8393 / HP / HC-P1:12.02.25

Hillingdon Council
Civic Centre, High Street
Uxbridge
UB8 1UW
Your Ref: 957/APP/2024/2765

Island Site, Eskdale Road, Hillingdon, UB8 2RT

We are writing in response to the Planning Application Review Form completed by Hillingdon Council dated 23rd December 2024, reference 957/APP/2024/2765. We have reviewed the comments and respond as below.

PROPOSED SITE PLAN - 1:500 @ A1
SCALE

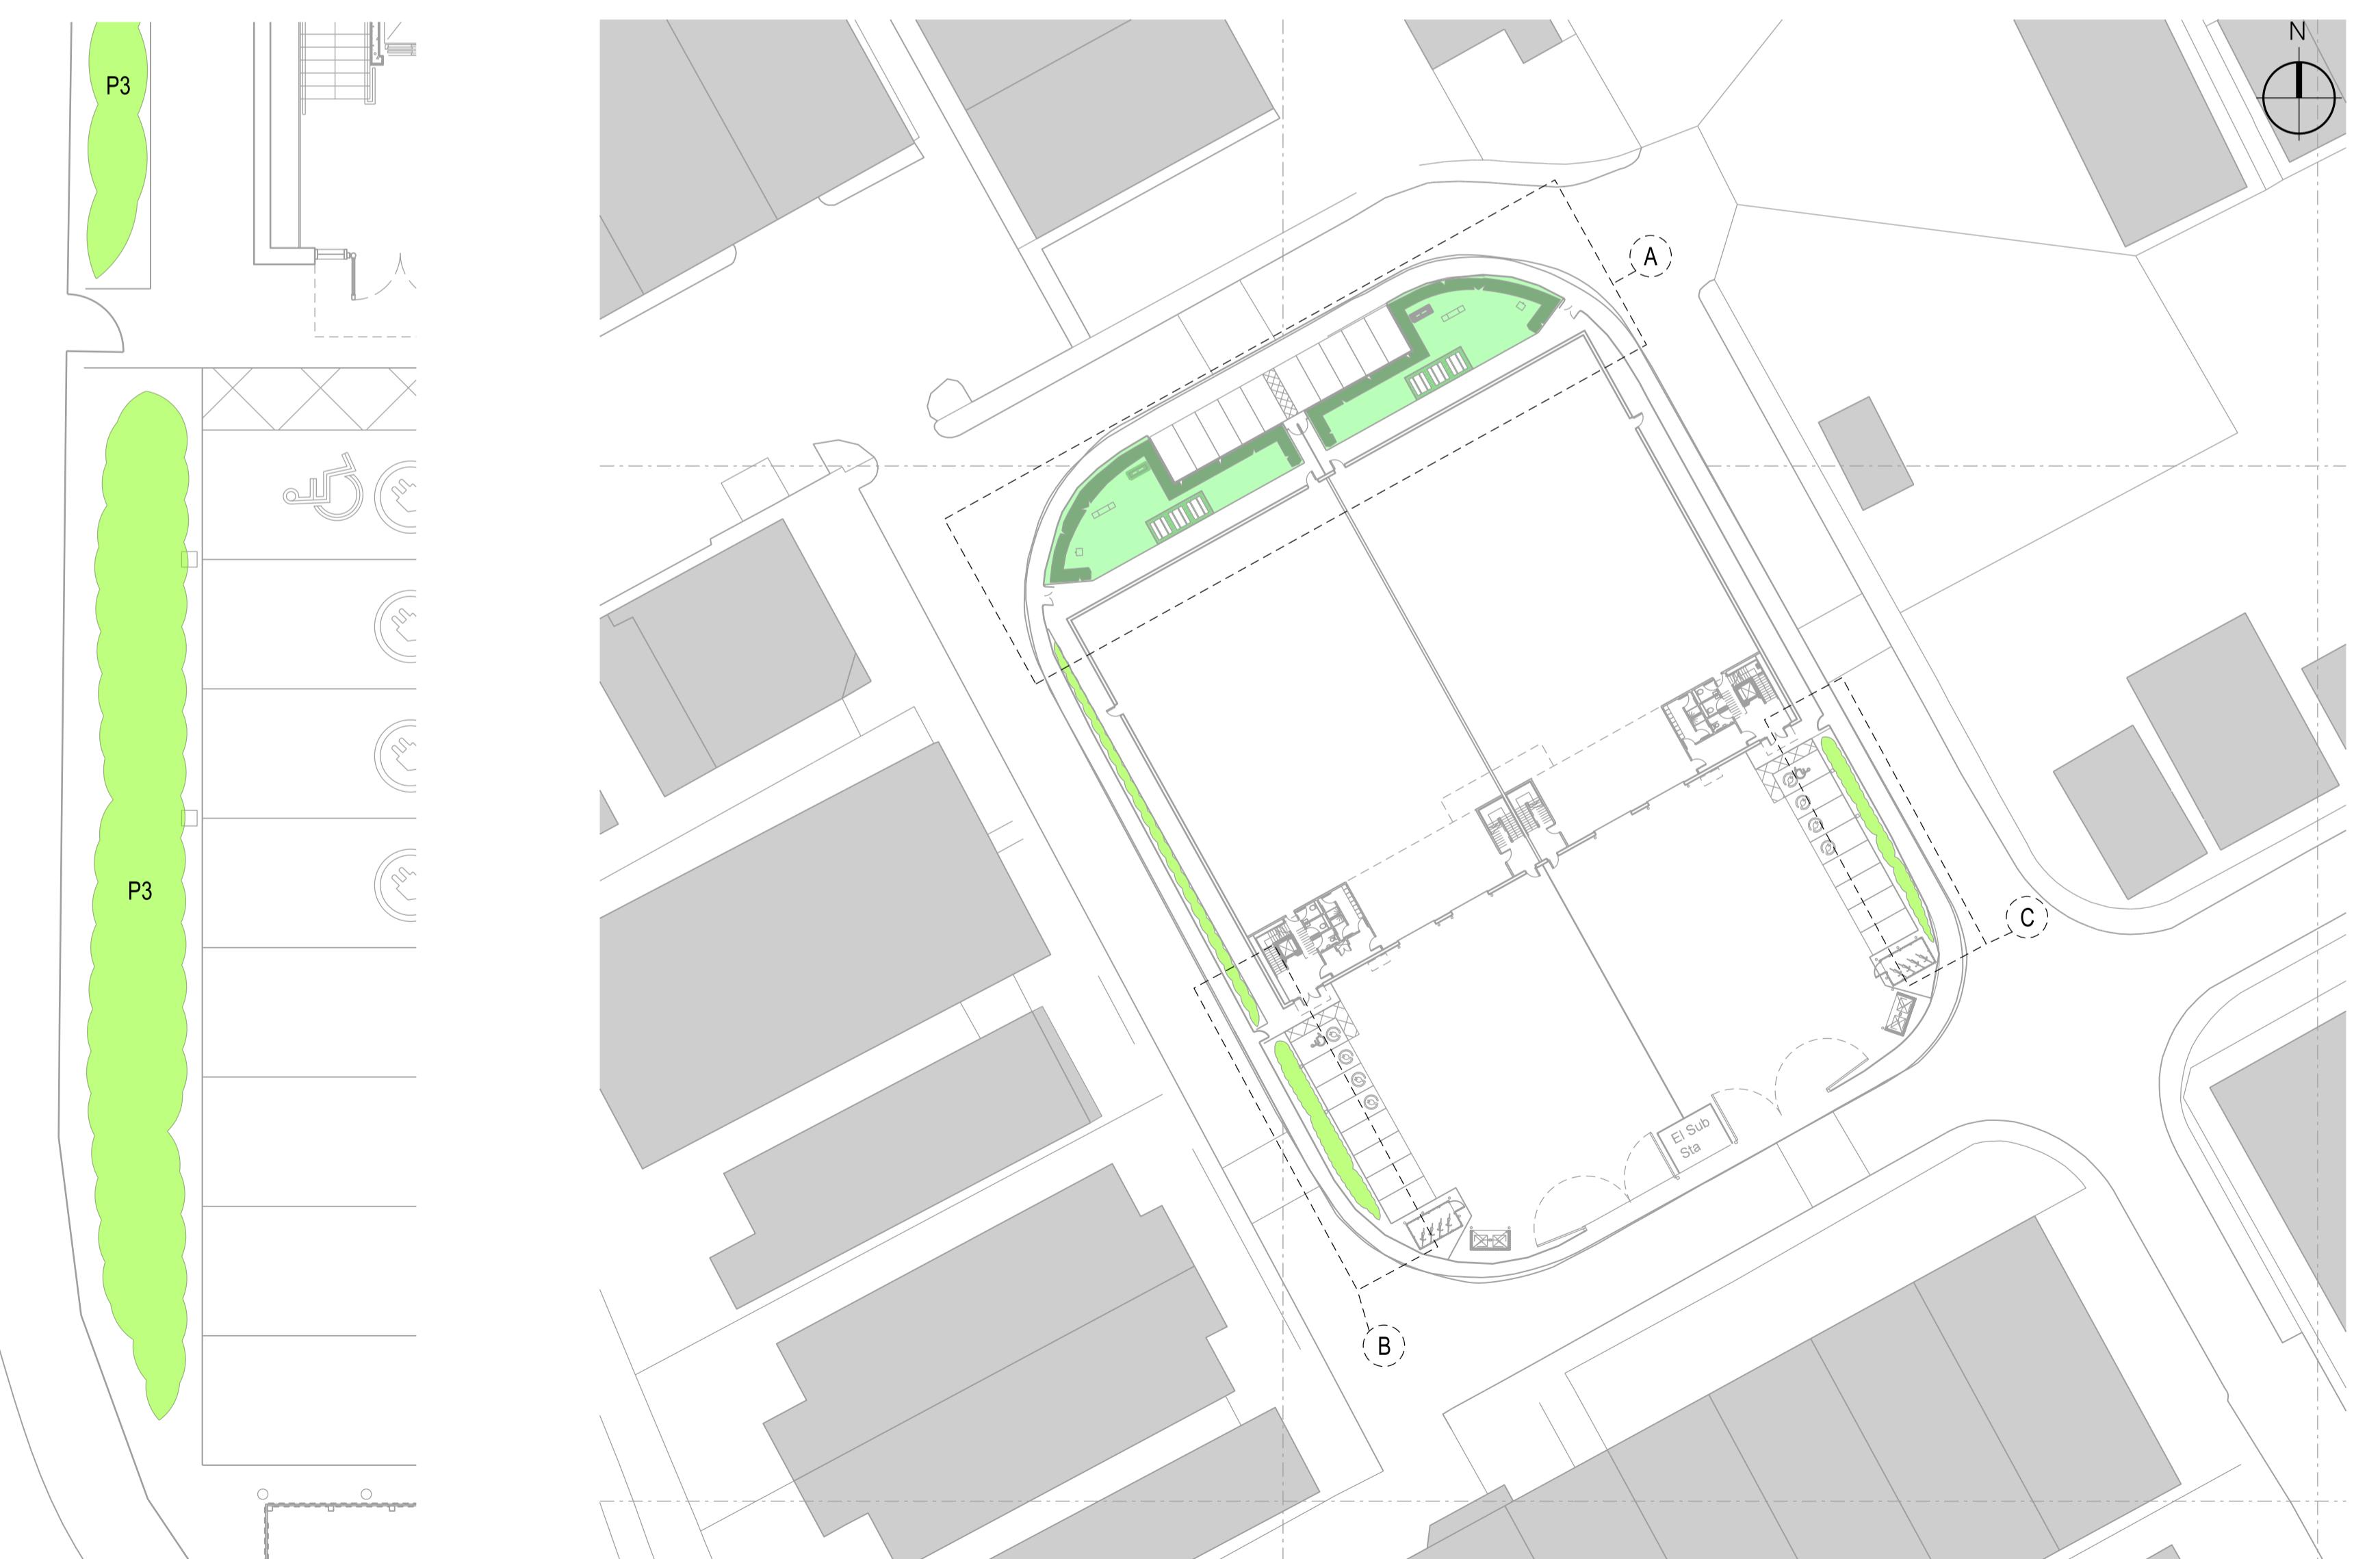
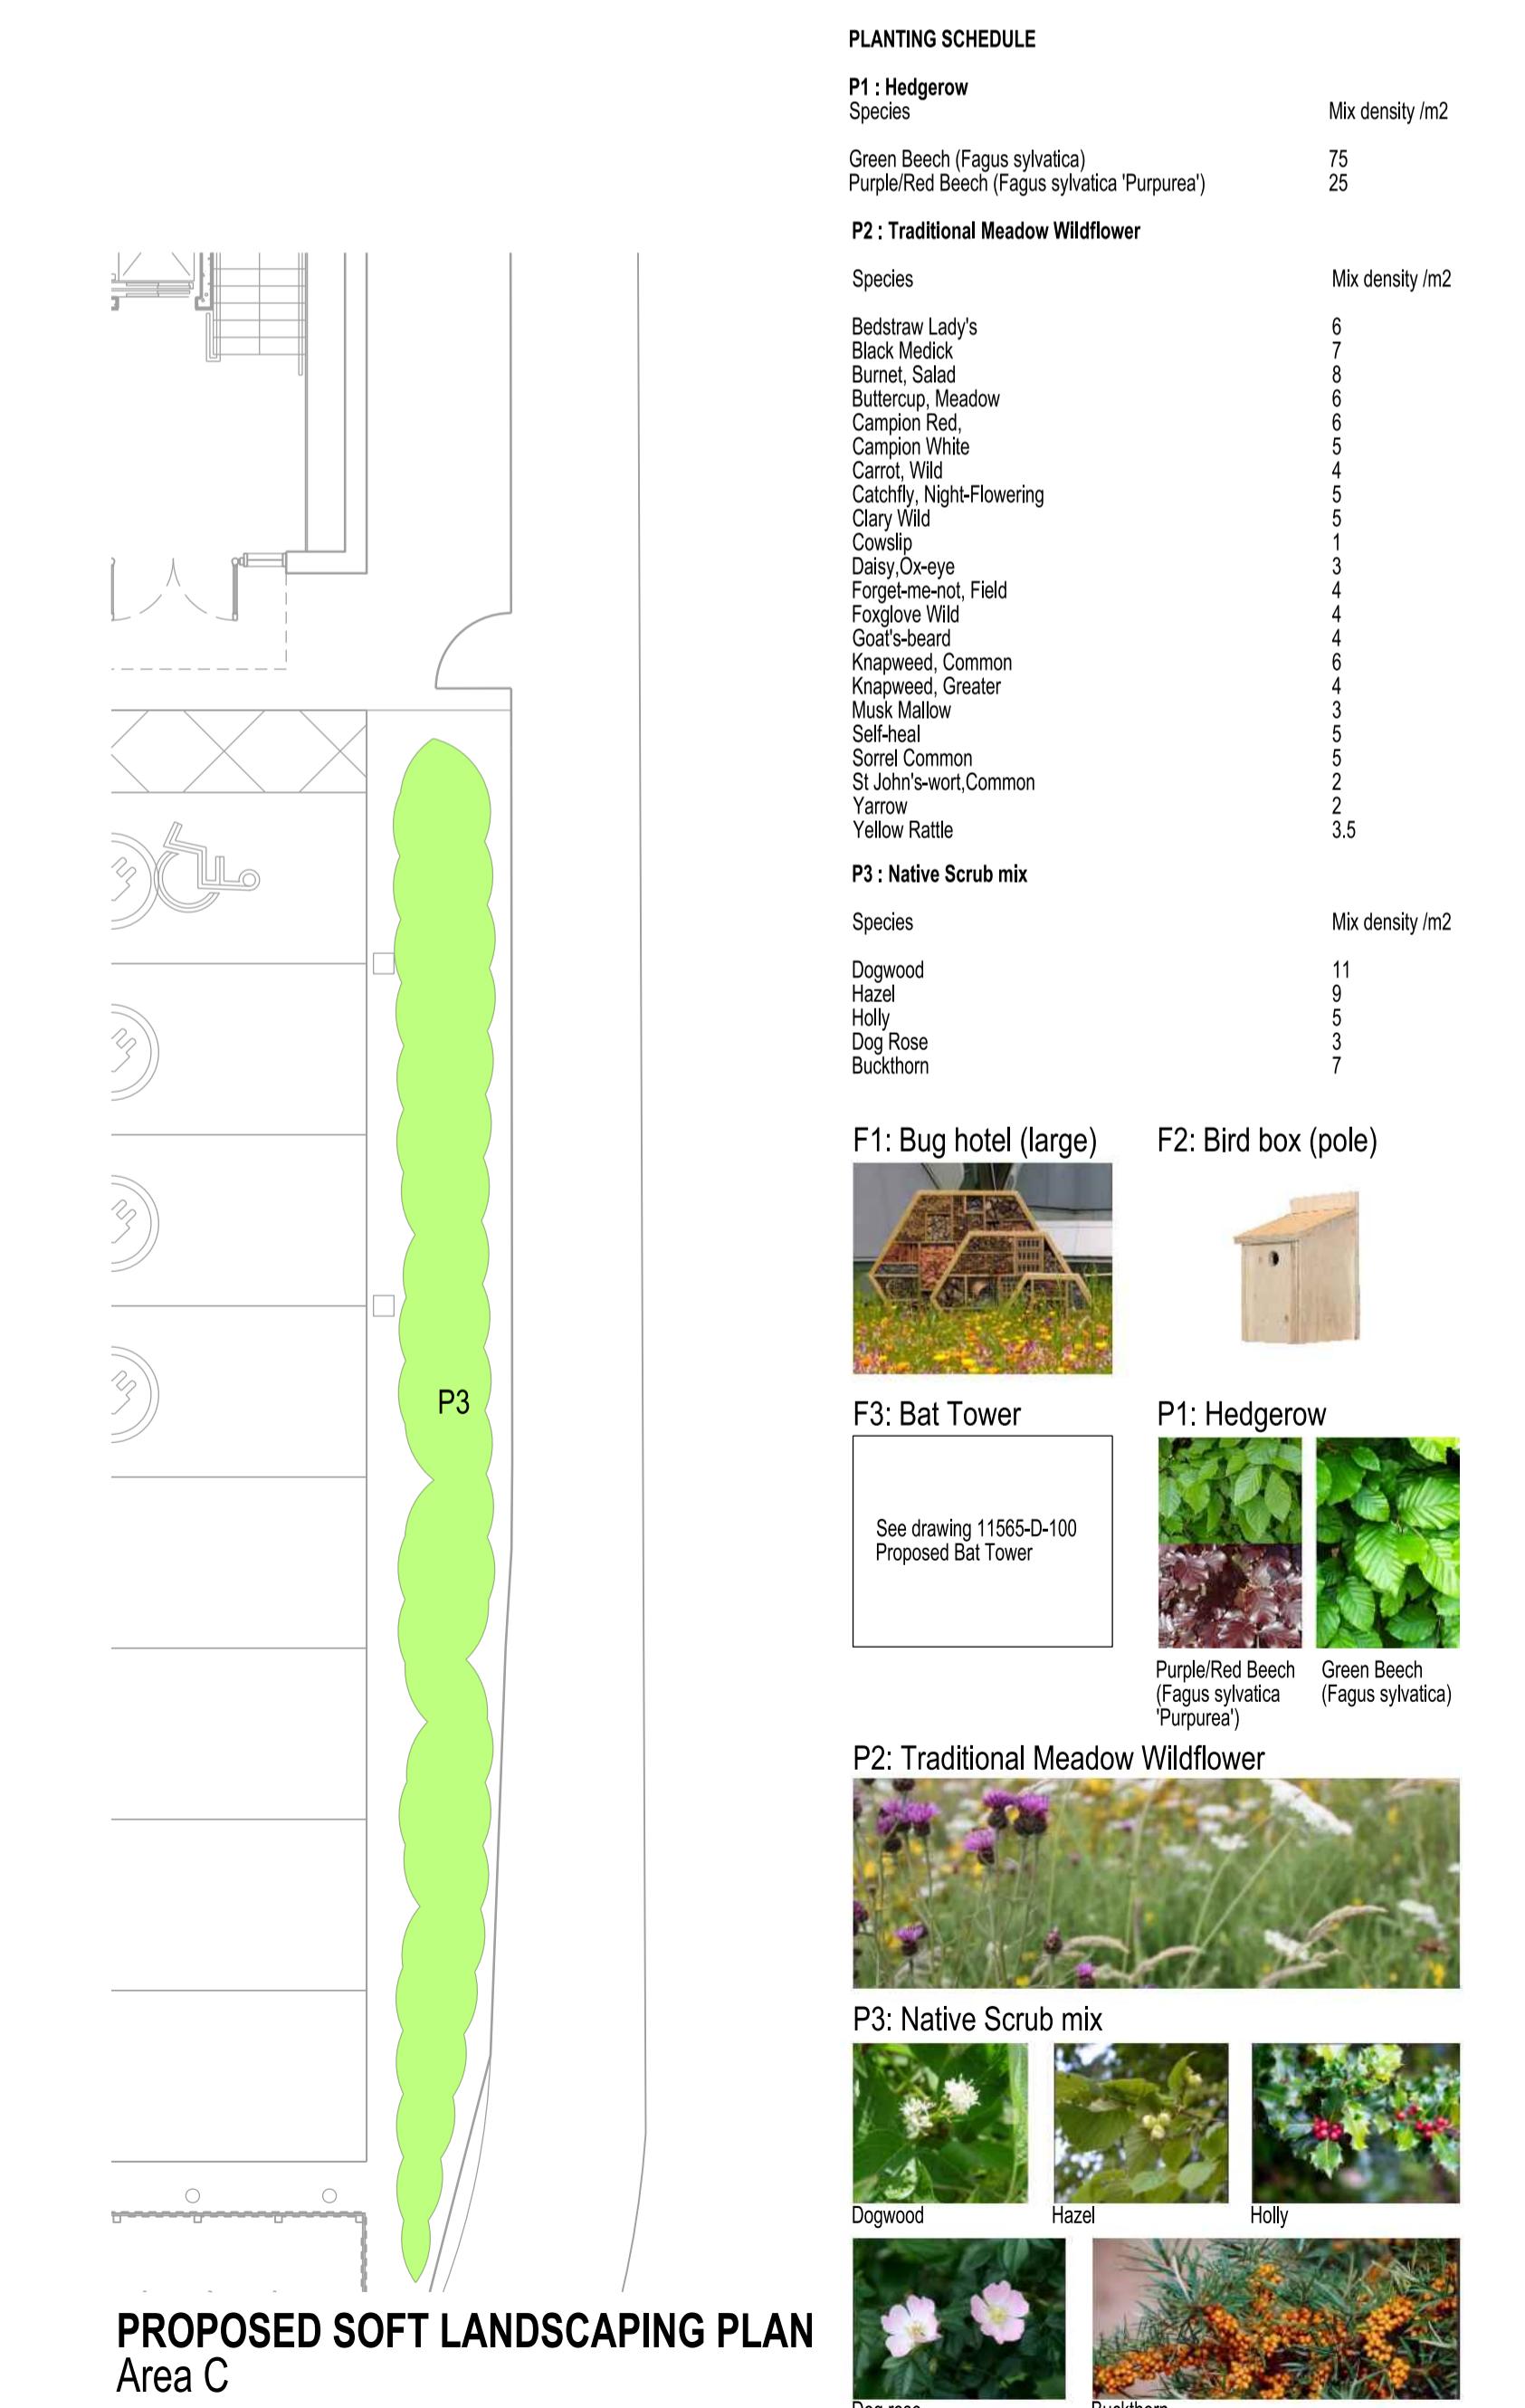
Implementation of Green SuDS Infrastructure / Rainwater Harvesting

The inclusion of site wide green SuDS infrastructure was not considered viable due to the limited space where they could be accommodated. The proposed site is constrained by the fact that most of the external area is required for HGV loading, unloading, and manoeuvring and staff parking.

However, soft landscaping has been proposed to the northern region of the site, which totals an area of 292m², an increase of 120m² compared to the existing site. The rainwater strategy design has been split into two siphonic systems; the southern elevation rainwater pipes comprise the primary system and will accommodate the first 120mm of rainfall, and the rainwater pipes proposed on the northern elevation have been designed as the secondary system and will take the rest. The secondary rainwater pipes will discharge on to this soft landscaped area. Although it has not been detailed yet, it is envisaged that perforated pipes will convey water along the base of the soft landscaping and then connect into the new below ground drainage system via an orifice flow control catchpit chamber. This design detail will be decided during a later stage of the project in coordination with the Landscape Architect.
